Our ref: P680020-FRA L01
Your ref: 21/02286/F

Re: Construction of a coffee unit with drive-thru facility and indoor seating with associated access, car parking, landscaping and servicing parking. Land North West of Launton Road roundabout adjoining Skimmingdish Lane, Caversfield

I refer to the recent Environment Agency consultation response (EA Ref: WA/2021/129266/01-L01) to the above application. This letter aims to take each item of objection and offer further information to allow the Environment Agency to make a more informed decision and remove their objection to the proposals.

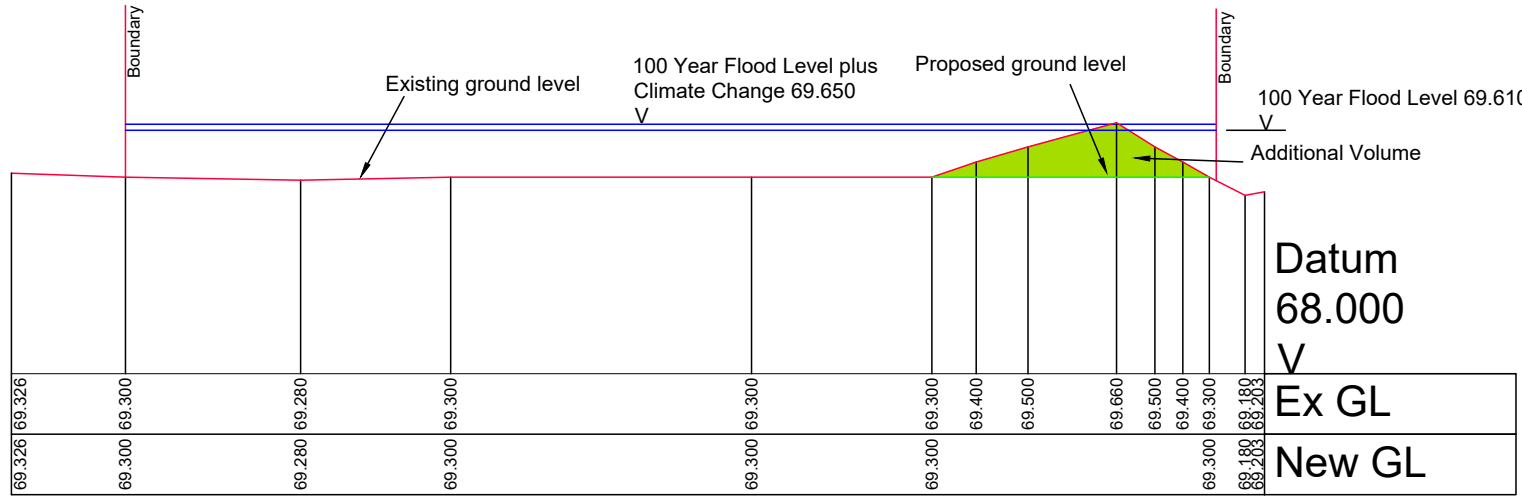
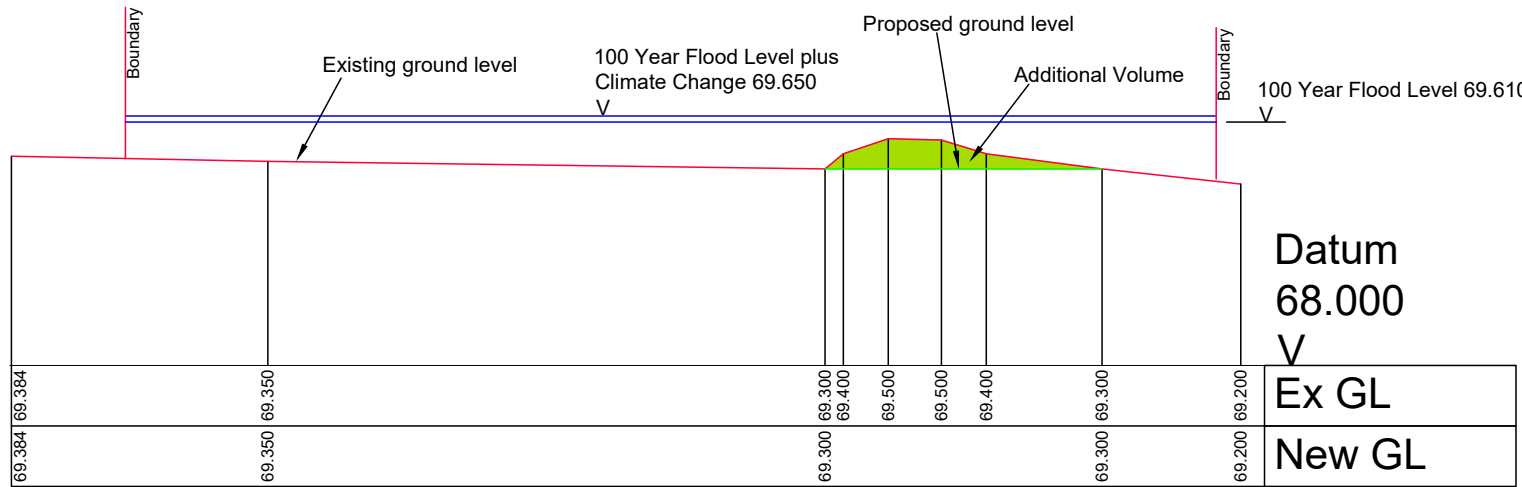
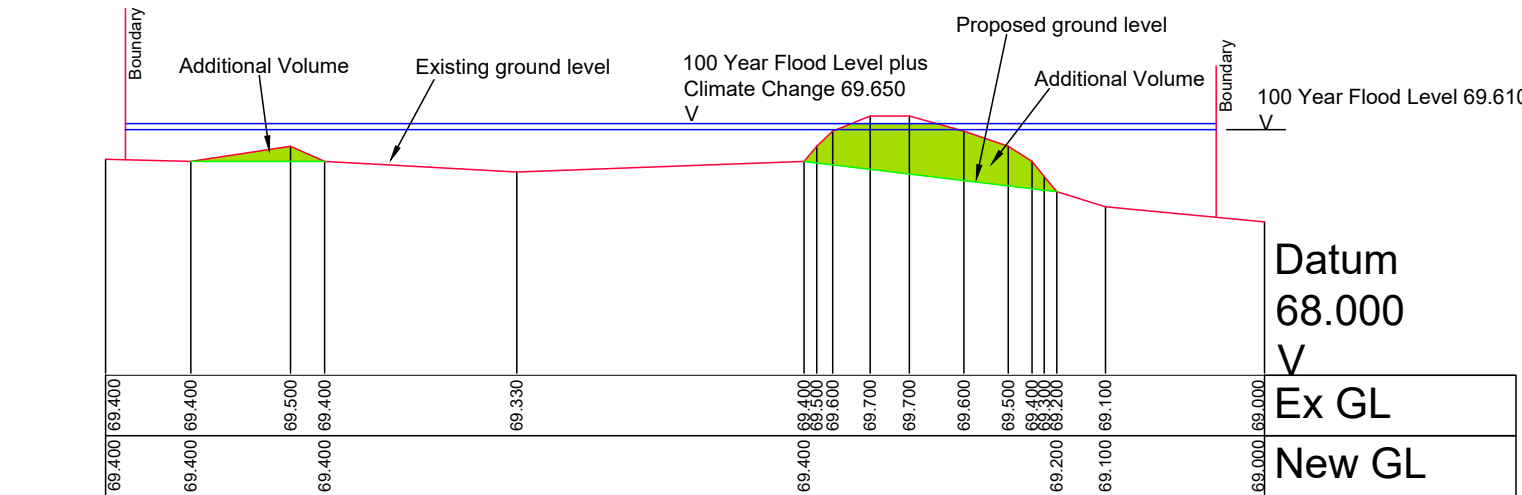
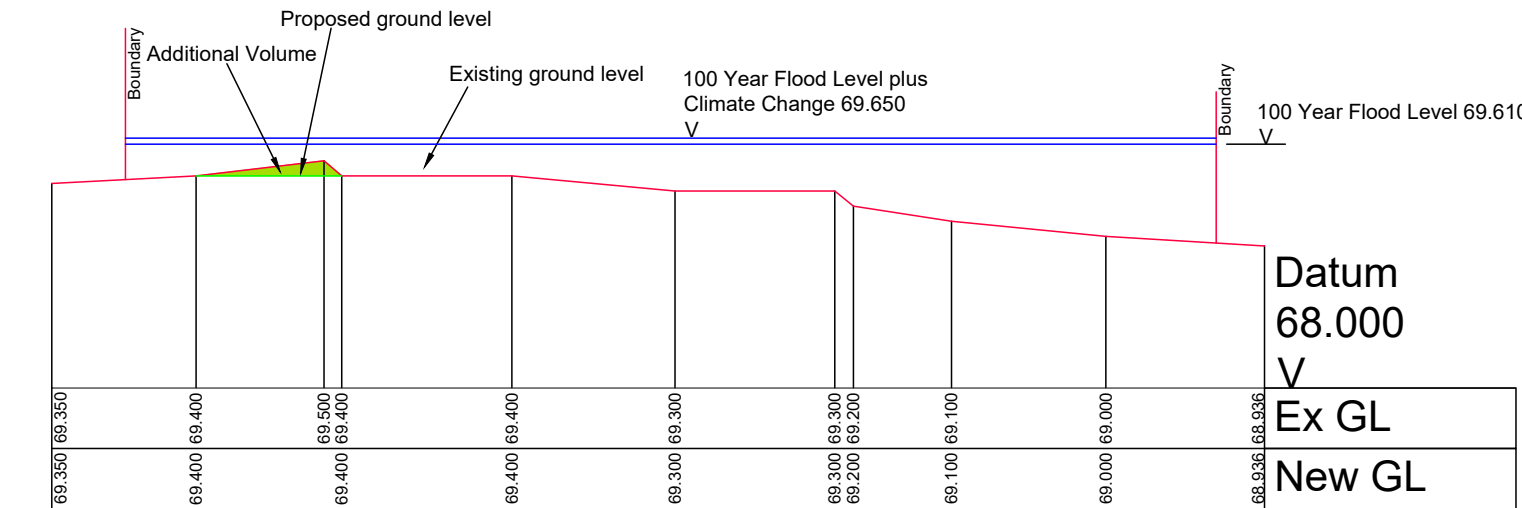
'In this instance, the applicant proposes to provide flood storage compensation for the loss of flood storage as a result of the development through the use of storage tanks in combination with some lowering of ground levels. The detail presented within the FRA is insufficient for the following reasons:

1. Proposes a method of compensation storage in tanks which is inappropriate to the storage size required;
2. Fails to demonstrate that storage tanks can be adequately maintained (free of silt and debris) and thus fulfil the flood storage requirement over the lifetime of the development;
3. Fails to demonstrate on a level for level basis that sufficient compensation storage has been provided;
4. Fails to provide sufficient information comparing existing and proposed levels across the site to demonstrate where flood storage is lost;
5. Fails to provide details of the ground lowering required to provide the 11.3m³ compensation storage element within the higher ground to the east of the development as mentioned in Section 4.3 of the FRA.'

It can be seen from the drawings (Drawing Ref: 220029/FV100 P1) and the associated tabulated data (below) that at the lower depth of flooding there is an significant increase in floodplain volume (per 100mm segment) as a result of the development (totalling 68.67m³ without any additional mitigation), however when the flood depth exceeds 69.550m AOD (which is a 1:100 year plus climate change event), there is a loss of floodplain volume per 100mm segment, this equates to a total volume of 36.5m³ of lost floodplain volume at these depths.

This letter and the enclosed drawings represent a revised scheme in terms of flood compensation with the aim of addressing the points raised. The latest drawings are enclosed, along with cross sections through the existing and proposed development to illustrate where floodplain is lost and where additional flood storage has been created as a result of the development. As requested by the Environment Agency, the impacts of the development on the floodplain per 100mm segment have been investigated and tabulated (see table below) and details of the offsite ground lowering has been provided on the enclosed drawings.

Overall, there is a net increase of 68.67m³ in floodplain volume over the range of flood depths. The results show that there is an additional requirement to provide floodplain compensation for the loss of floodplain volume (for 1:100 year event plus climate change) from a depth of 69.550m AOD of 17.58m³ and 18.92m³ from 69.650m AOD, a total requirement of 36.5m³ which will be provided in underground attenuation tanks with an inlet to mimic the level at which the volume is lost. As a result, at these extreme flood depths, there will be no net loss of floodplain volume as the tanks will provide the required volumes at the depths at which the floodplain volume is lost (i.e. 65.55m AOD and 65.65m AOD). The inlet levels will be set to ensure no floodwater will enter the system before these flood depths are reached ensuring that the volume requirement is available at the correct time of the flood event.

It is noted in the letter from the Environment Agency that the volume requirement for these tanks should be closer to that previously agreed of 30m³ flood storage. Whilst the 36.5m³ is a minor increase in this volume, with the addition of this attenuation the development offers a significant net increase in floodplain volume of 105.16m³ over the full range of flood depth segments including the use of the tanks (Table 2).

The use of underground attenuation requires a maintenance programme to ensure the system is ready for use at the onset of a flood event. It should be noted that the system will only be utilised when the flood depths on site reach 69.550m AOD and will not receive any surface water drainage from the site, they will be flood compensation tanks only and desilted after each time flood waters enters the system. To confirm the foul and surface water drainage systems for the site are isolated and will not interact with the floodwater attenuation system. A programme will be established and agreed with the Environment Agency to ensure this is the case. The system will allow for access for inspection and necessary works to be undertaken. The detail of the programme should be agreed with the Environment Agency prior to commencement and secured through an appropriately worded planning condition.
